Application for a non-material amendment following a grant of planning permission.
Town and Country Planning Act 1990

Erection of single and two storey rear extension to dwelling

2016/1095

Installation of two side facing rooflights, obscure glazed

Drawing Number: 2019/TP/005

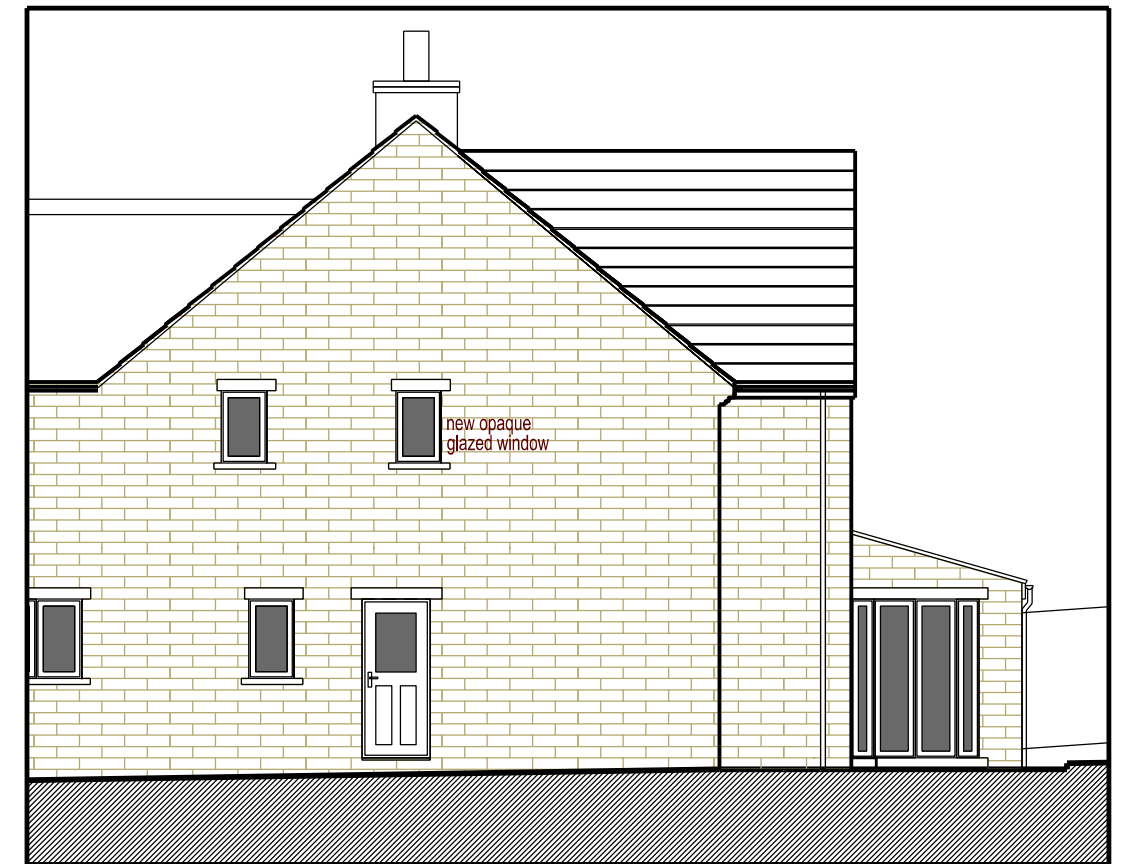
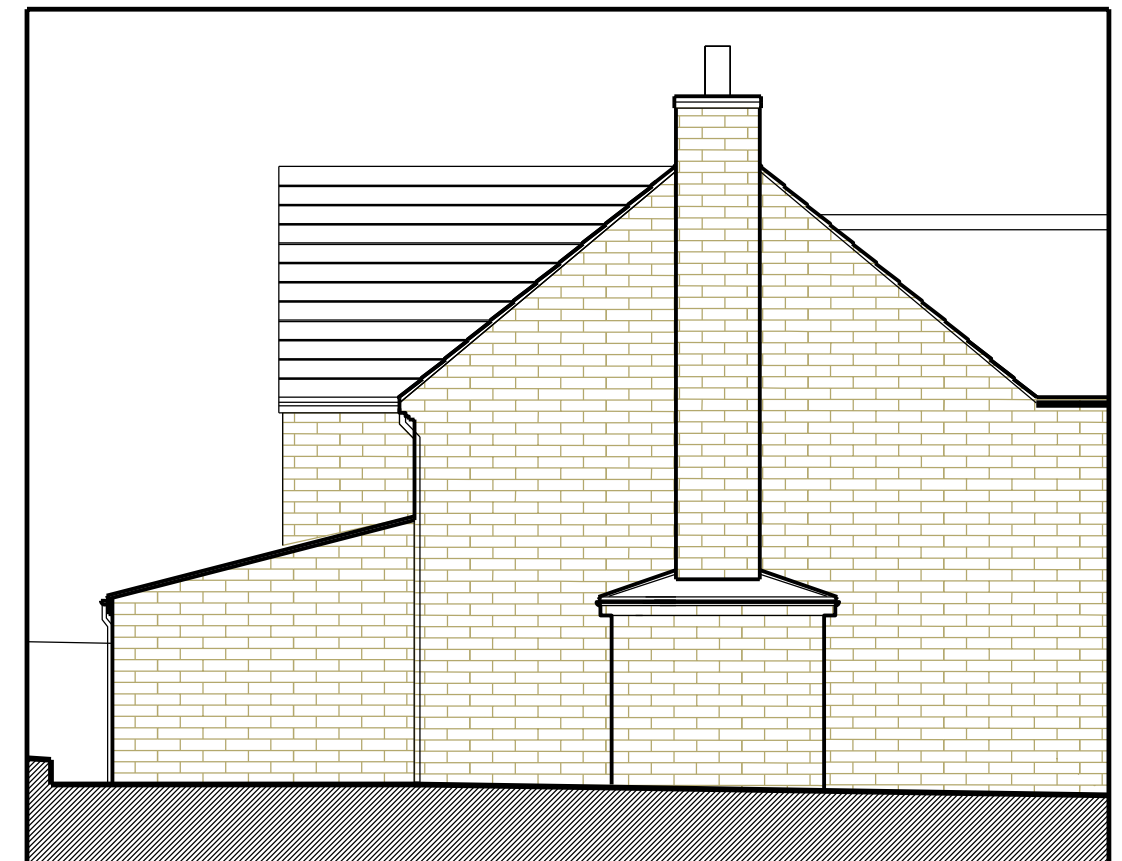
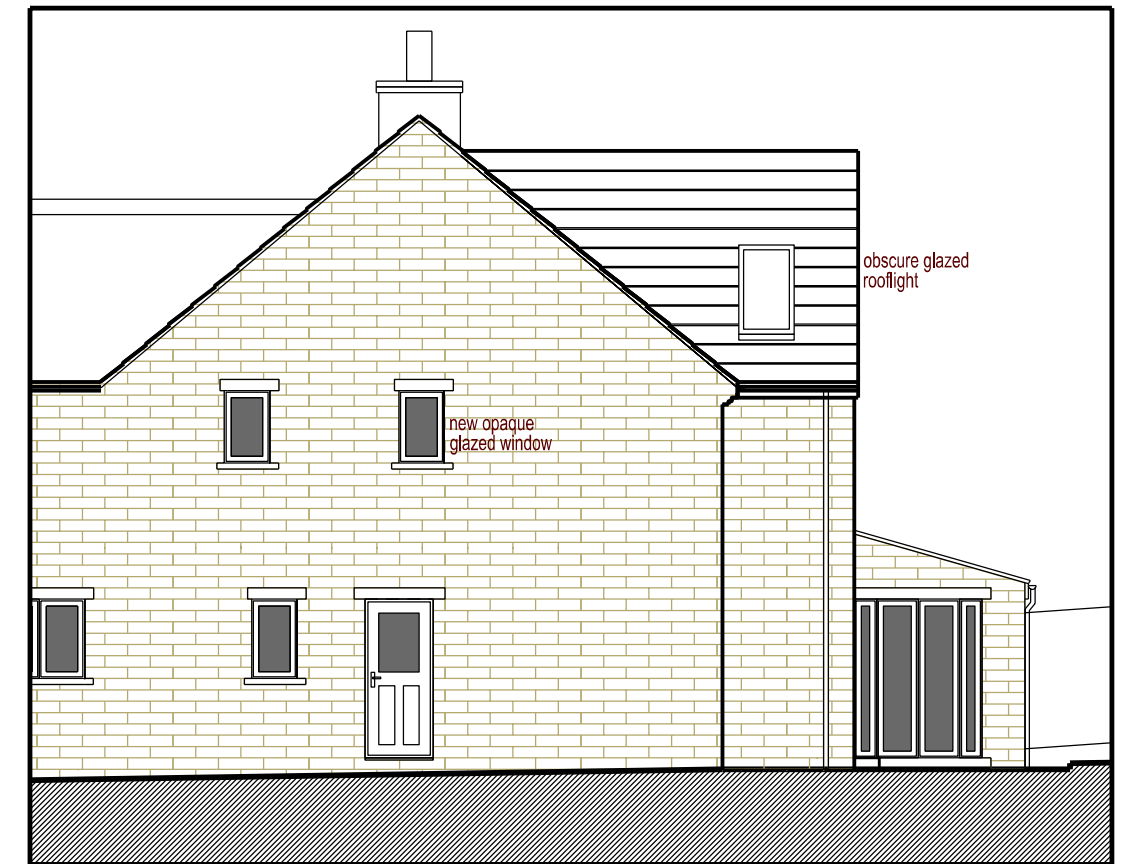
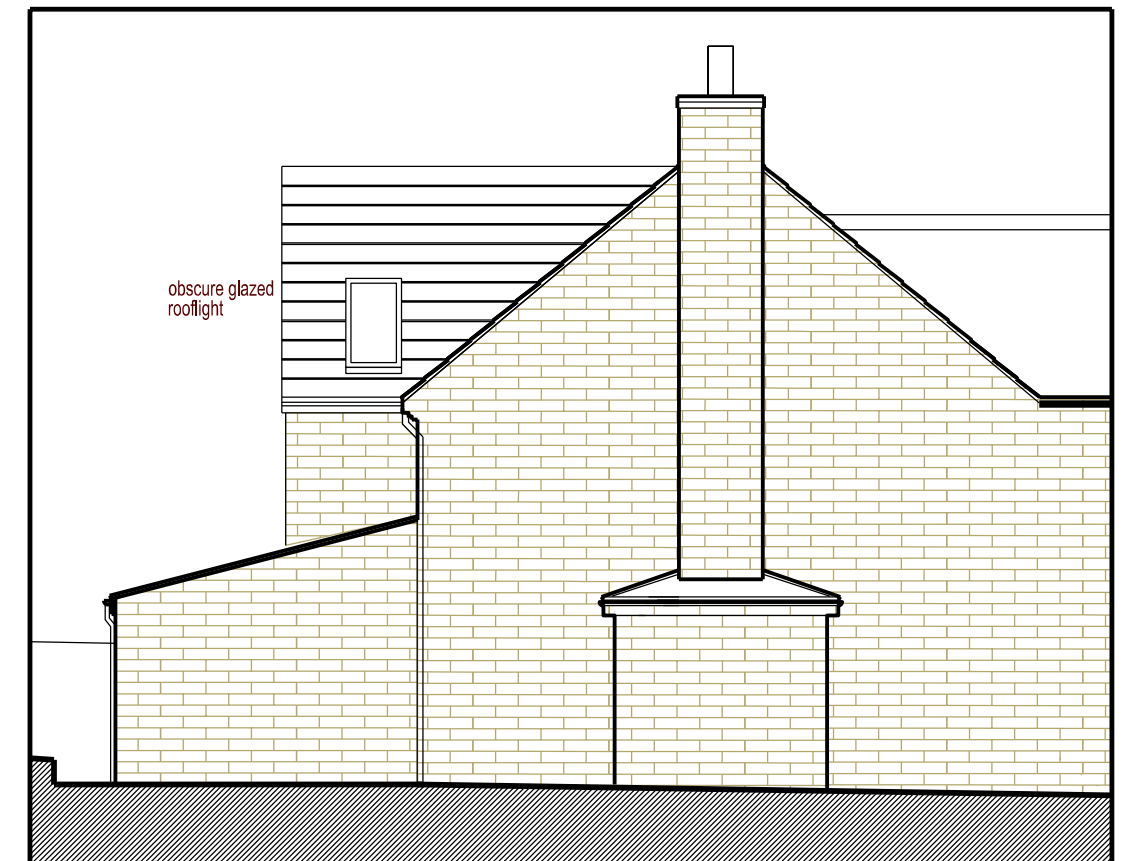
Old plan/drawing numbers: 2019/TP/005, 2019/TP006

New plan/drawing numbers: 2019/TP/005A, 2019/TP006A

requires the rooflights to be obscure glazed
